EPC STORMWATER REVIEW COMMENTS  
IN ORANGE BOXES WITH BLACK TEXT

Final Drainage Report  
for  
**Rolling Hills Ranch North Filing 2**  
at  
**Meridian Ranch**

**MERIDIAN RANCH**  
A GOLF & RECREATIONAL COMMUNITY

July 2024

No.	Date	Appr.	Date

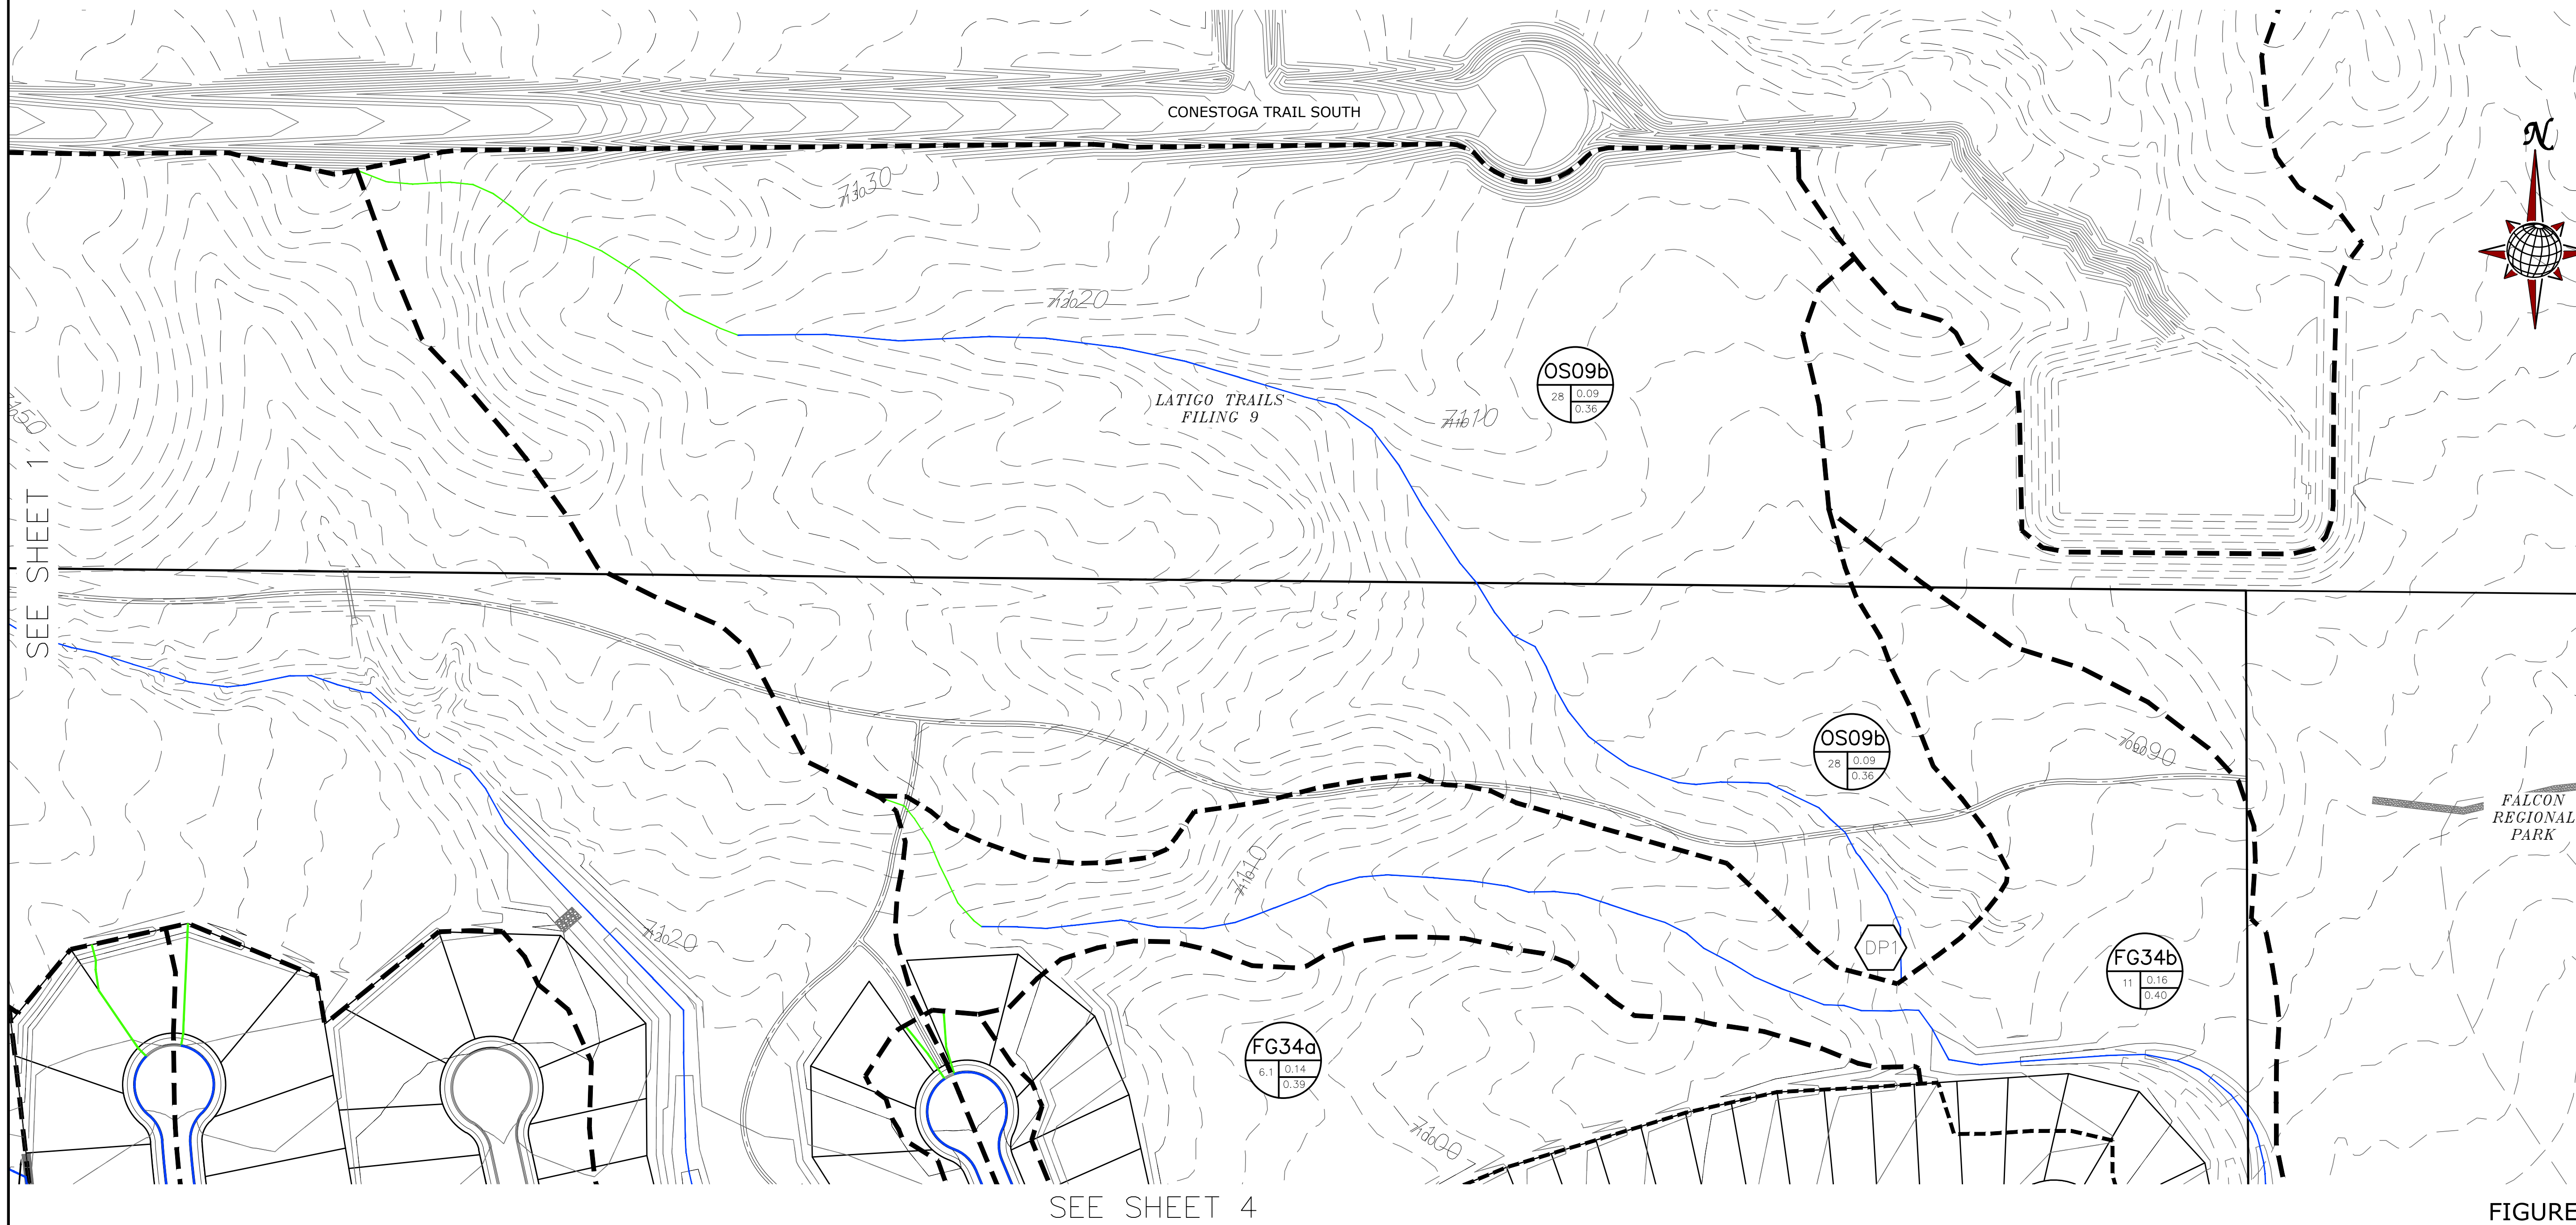
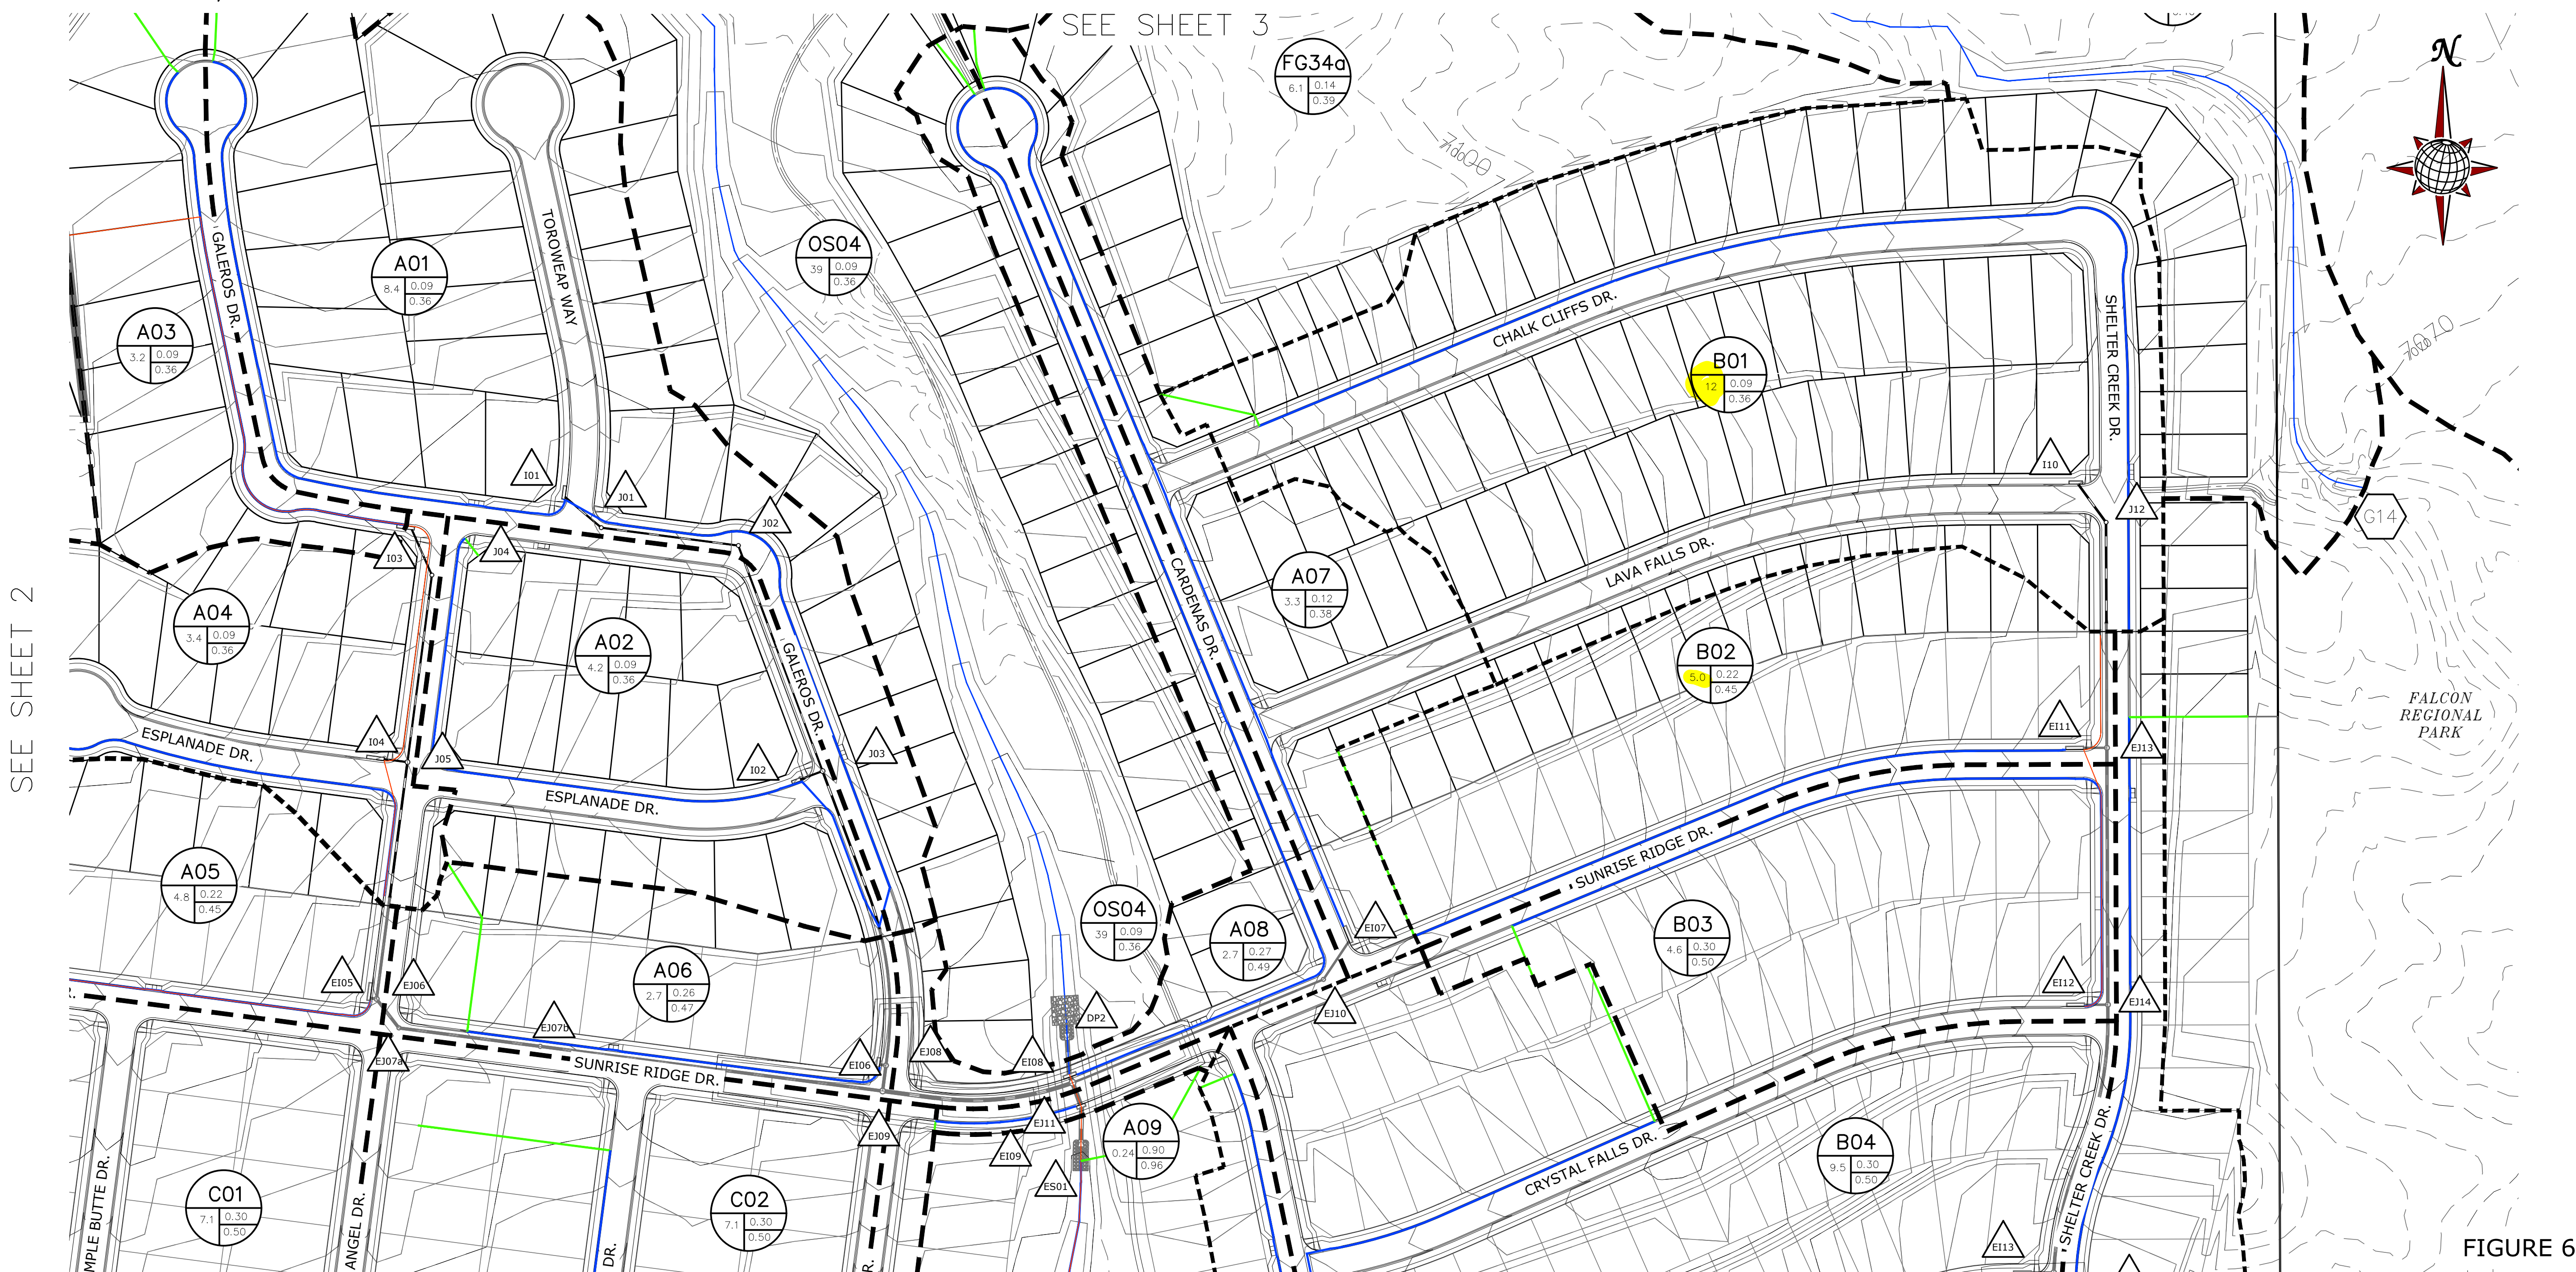
For all sump inlets, the emergency overflow path in the case that the inlet becomes fully clogged needs to be discussed.

Please mention the proposed 18" RCP and the existing RCP, as there are two sections of pipes in this area.

It appears there are existing storm pipes and inlets within the project area. Please assess their capacity to handle the proposed runoff and provide hydraulic calculations for an existing storm pipes and inlets.

Please revise the highlighted numbers to match the calculations and summary table.

Please revise all calculations for the highlighted numbers.  
These numbers do not match the summary table.
